RE: Case Reference: 320916, 320095 and 320094

Applicant: Coolpowra Flexgen Limited

Development: BESS, GAS Plant and GIS Substation

Client	COOLPOWRA FLEXGEN LIMITED		
Project	COOLPOWRA (GIS)		
Title	PROPOSED SITE SURFACE & FOUL WATER LAYOUT		
Stage	PLANNING

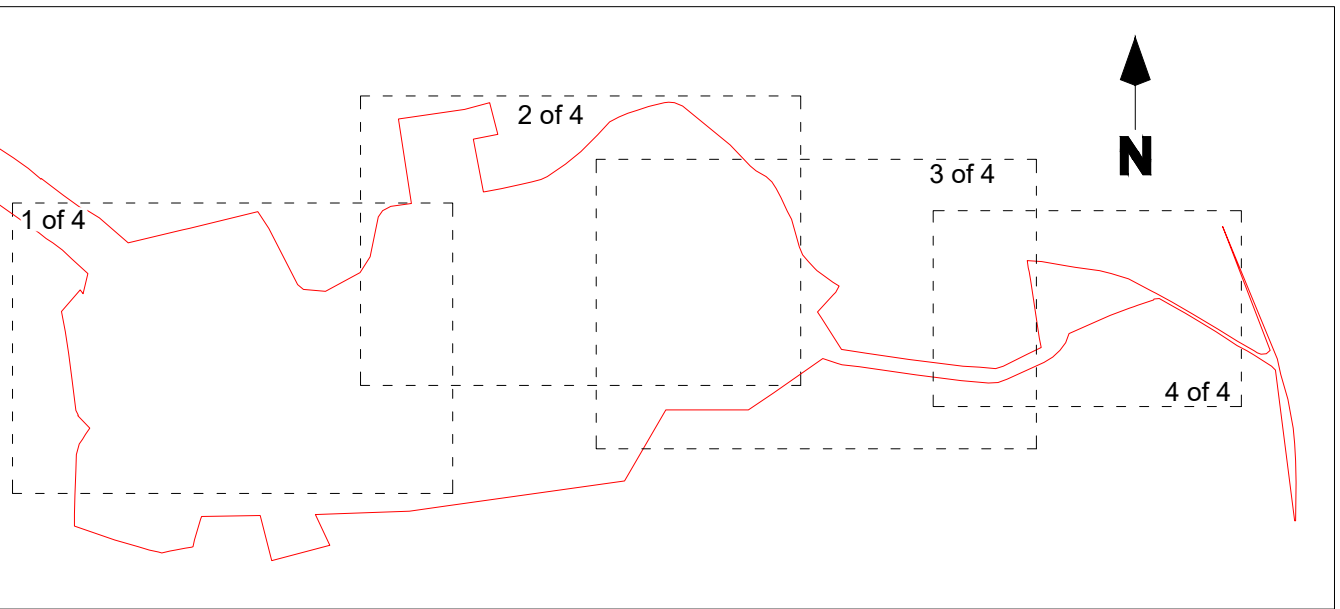
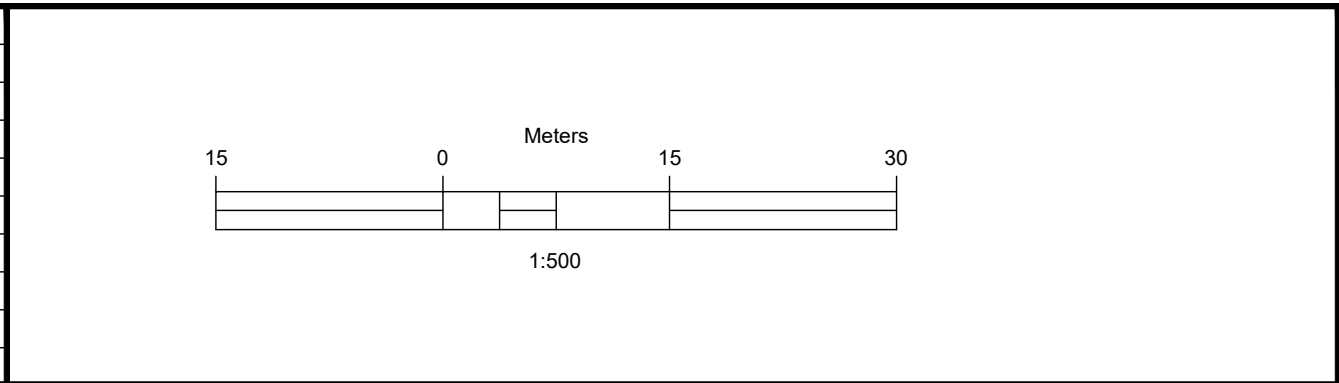
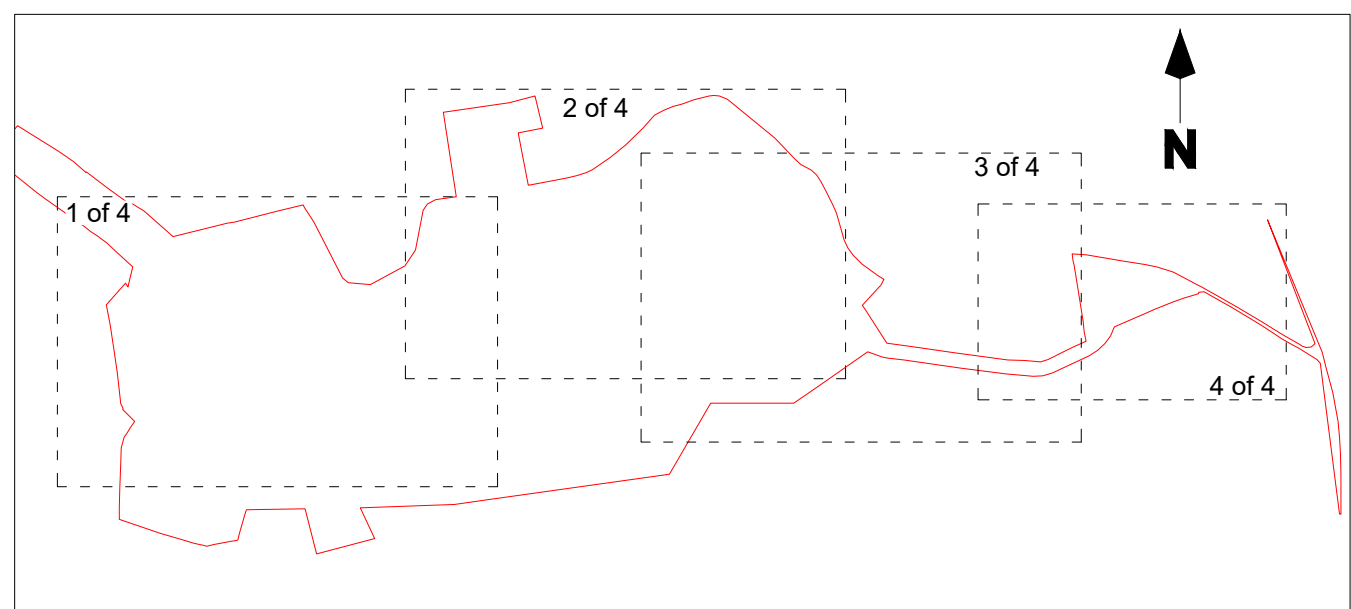
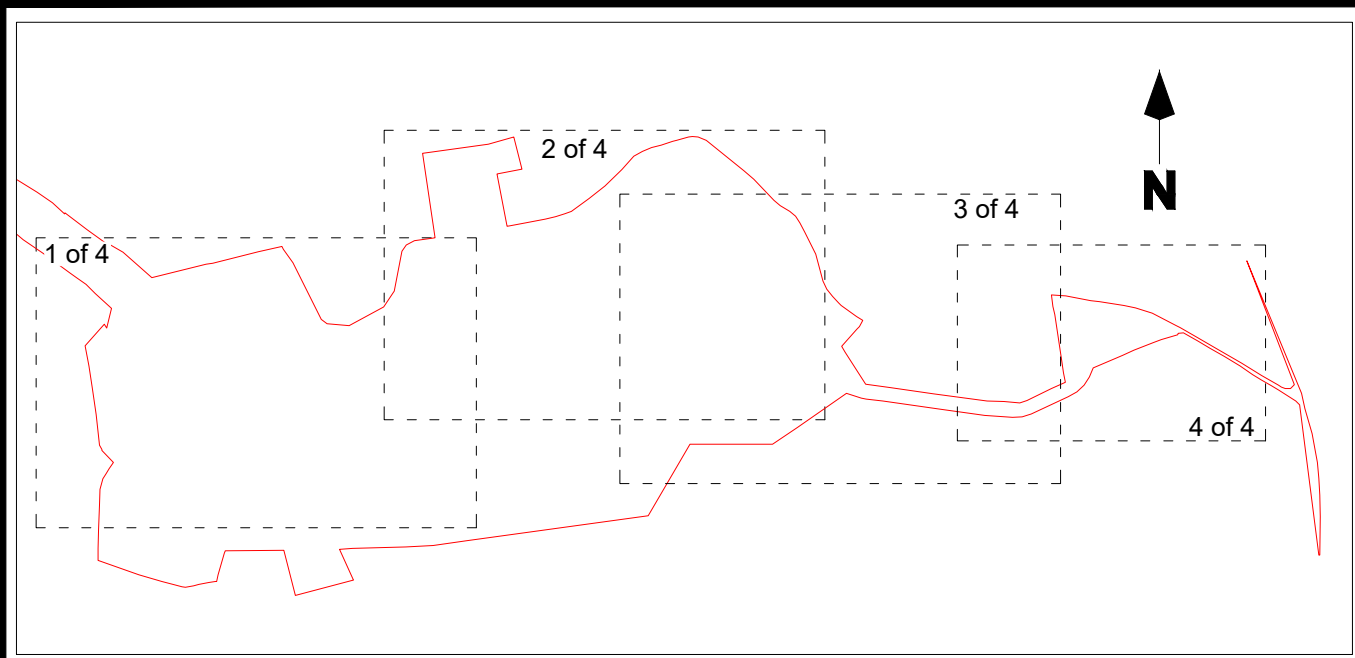
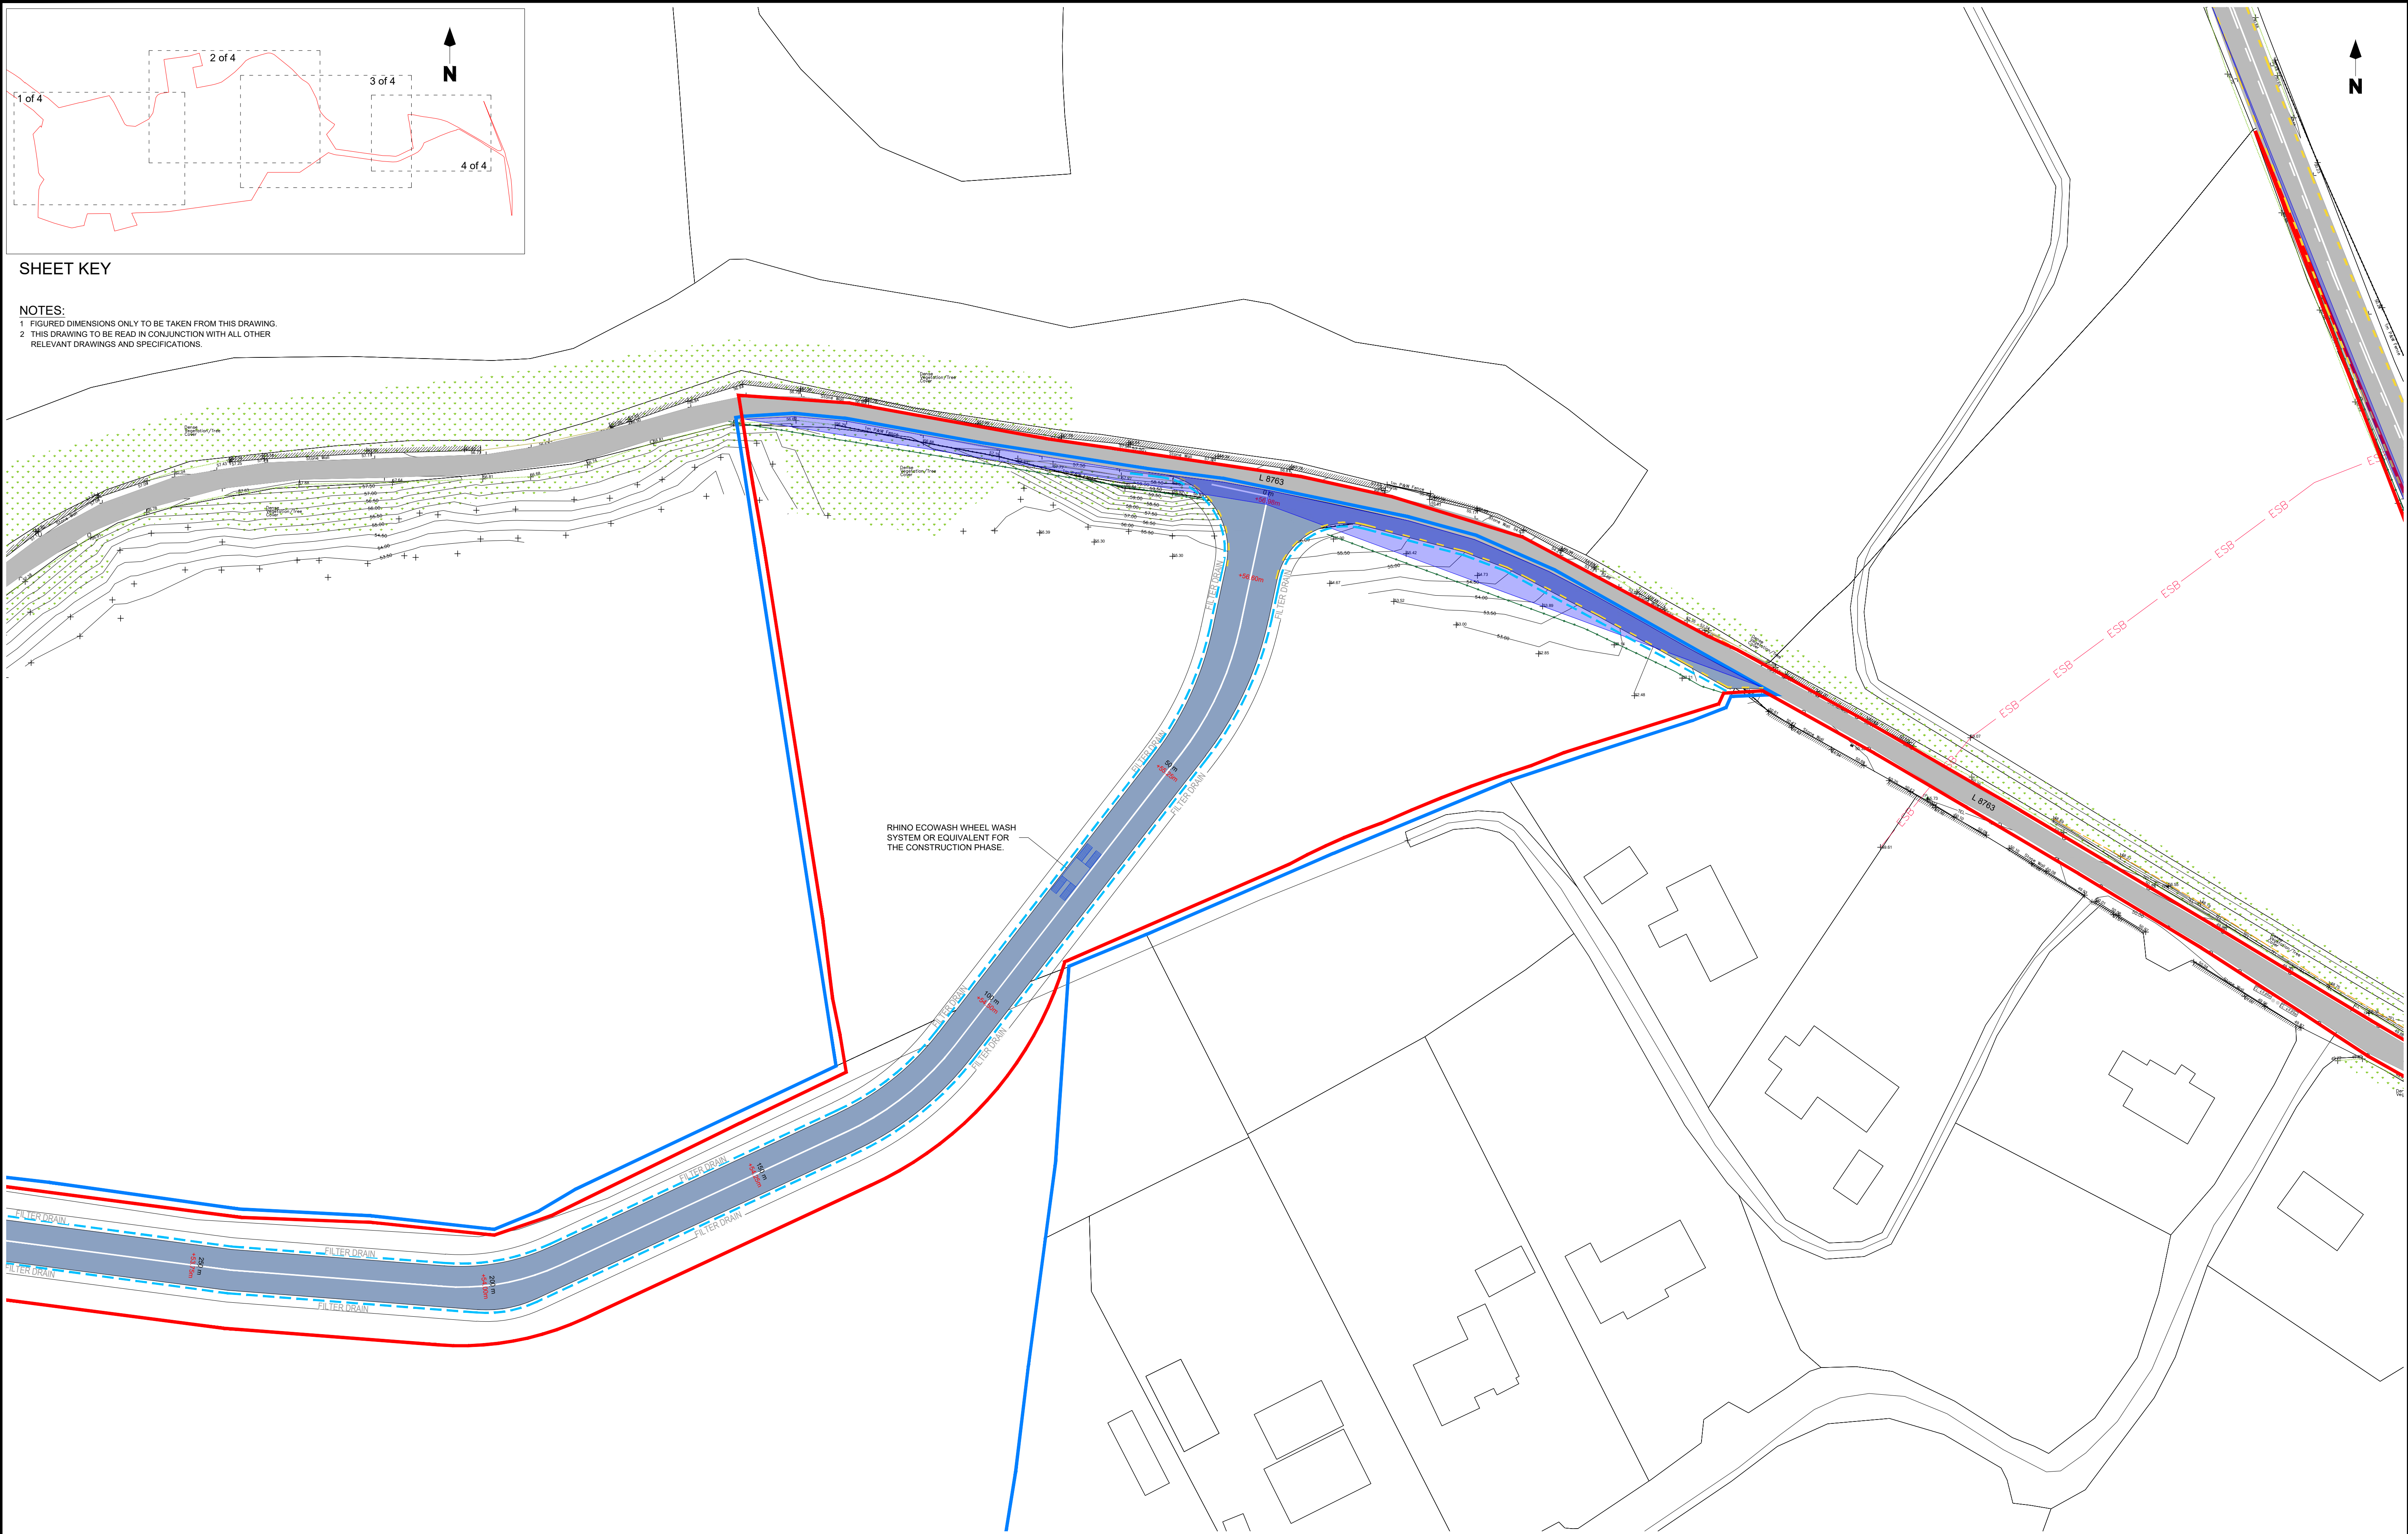
- **Redirection of Treananearla stream:** redirecting a small section does not avoid that fact that the majority of this stream will still travelling through the centre of this large scale site, in particular closely bordering 2 sides of the BESS. Should there be a fire at the battery facility (which is not uncommon in Ireland eg Claregalway) the stream will be directly hit.
